Moorebank Precinct East - Stage 2 Proposal, Environmental Impact Statement, Part 4, Division 4.1, State Significant Development, December 2016

Narelle and Paul van den Bos make this plea to all professionals who will evaluate our submission:

Figure 5-8 Proposed Pedestrian and Cyclist Connectivity

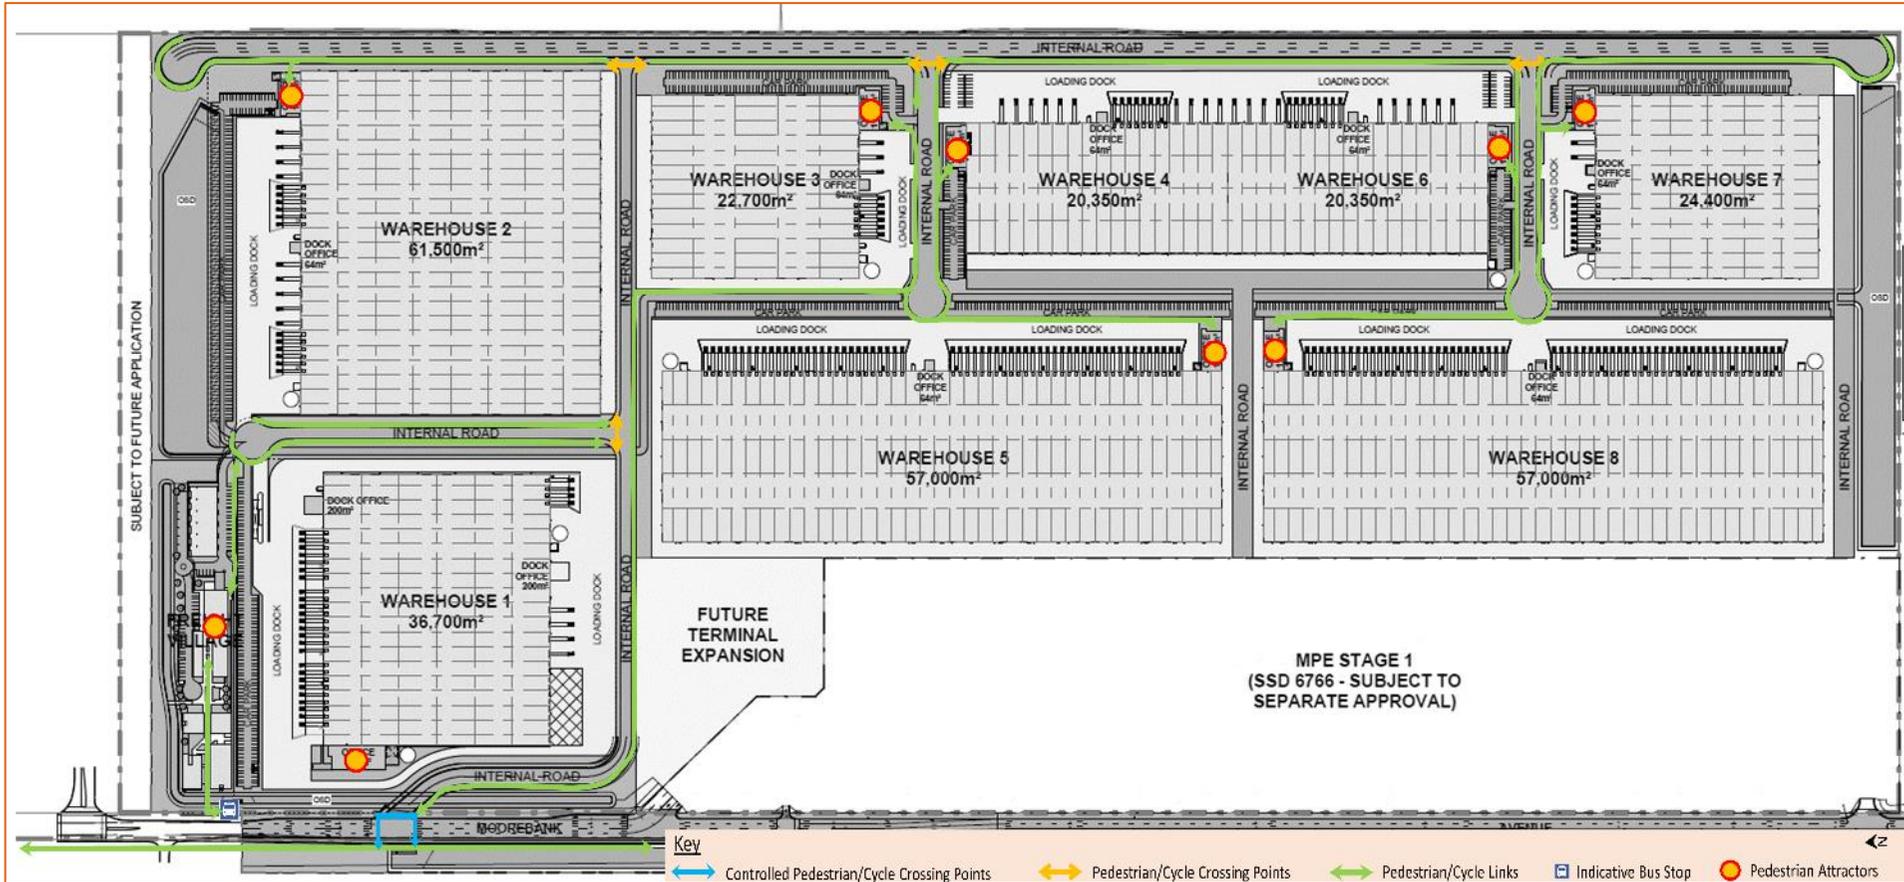
<p>[Page 73] Where is Figure 5-8 Proposed Pedestrian and Cyclist Connectivity?</p>
